Dear Sir, Planning Application AW/159/13 72 Barrack Lane

Objection to Planning Application AW/159/13 (78 Barrack Lane)

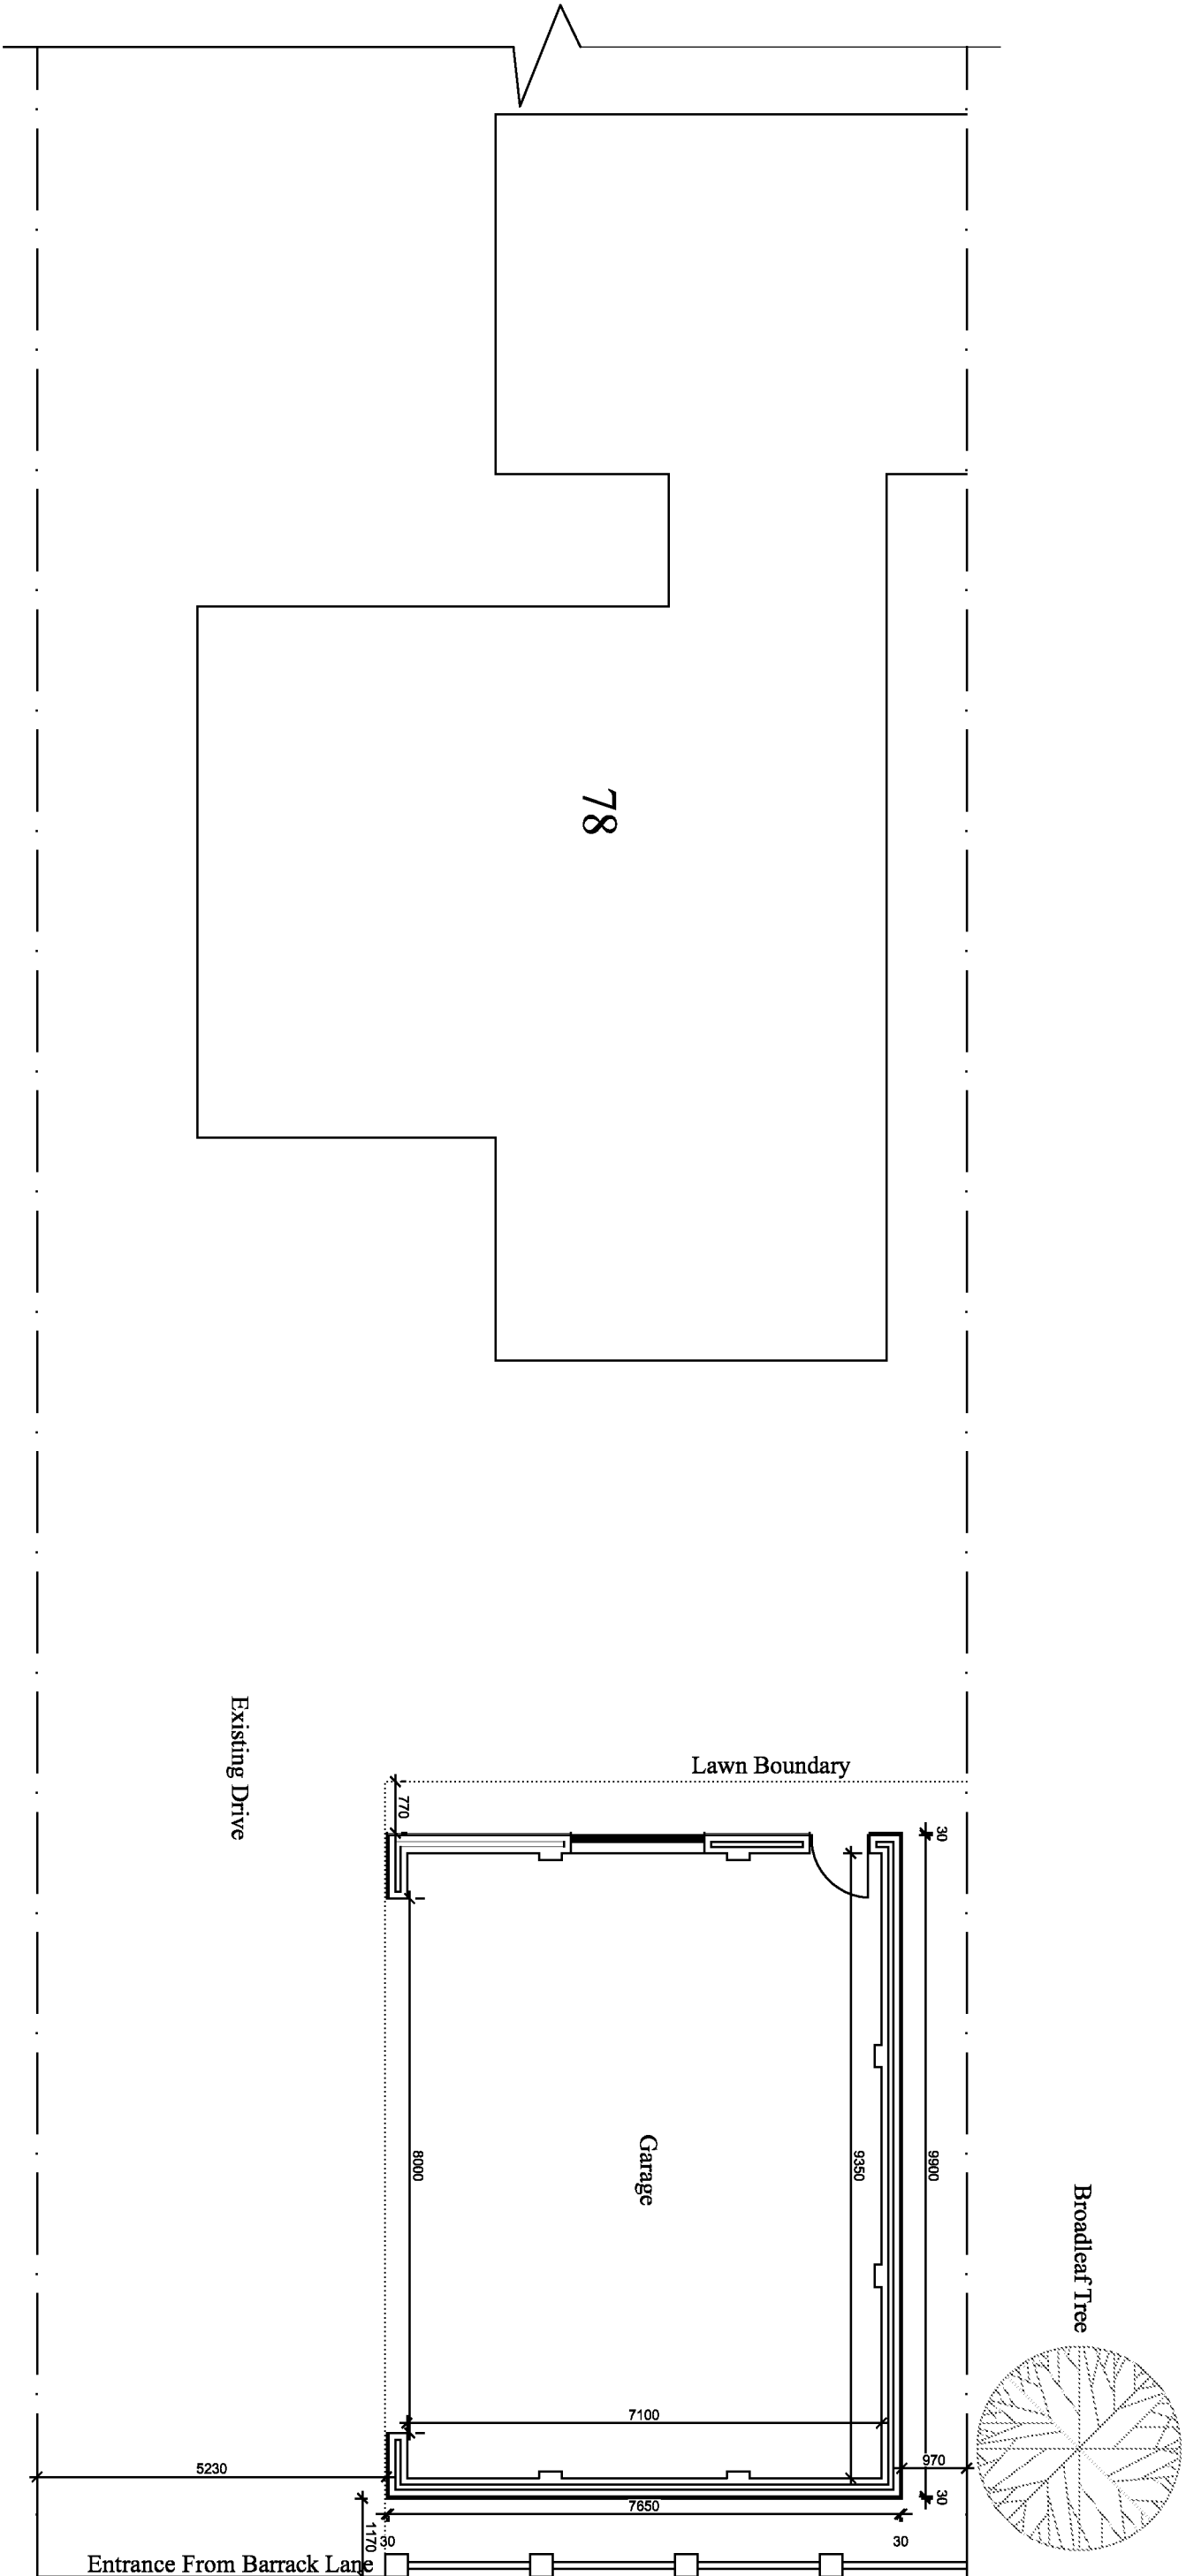
Also I understand that most, if not all our mature trees are protected by preservation orders. There are well grown trees on this site which would be affected by this proposal, either through damage during construction or subsequent root damage.

With reference to the above planning application, I wish to state my objection to the building of a garage in the front garden of 78 Barrack Lane, Aldwick, Bognor Regis.

In the corner of my property, at 74 and 76 Barrack Lane, abutting the garden of 78 Barrack Lane, there are two mature hornbeam trees, with roots that undoubtedly extend far under the garden of 78 Barrack Lane. Building works for the intended garage at 78 Barrack Lane would interfere and damage the roots of these trees, with possible irreversible damage to the health of the trees. Both hornbeams are subject to a Tree Preservation Order and are noted on the TPO/AW/3/94 as T11 and T12.

A large garage at the front of the property at 78 Barrack Lane, covering the majority of the existing lawn area, would also not be in keeping with this area of Barrack Lane, which has been noted by the Council as an Area of Special Character. The 'building line' in this area of Barrack Lane is set a considerable way back from the road, and has been adhered to since the land was sold for residential building in the early 1920's. The erection of an imposing structure, close to the road, would therefore not be in keeping with sustained appearance of the area, nor with the accepted 'building line' along the road.

There is also a submerged water course, which runs near to the road on the side of the road where the properties of 74, 76 and 78 Barrack Lane lie. This was first in evidence during heavy rains when we took over the property at 74 and 76 Barrack Lane. A building with the necessary foundations over this submerged water course might cause problems elsewhere along this road.
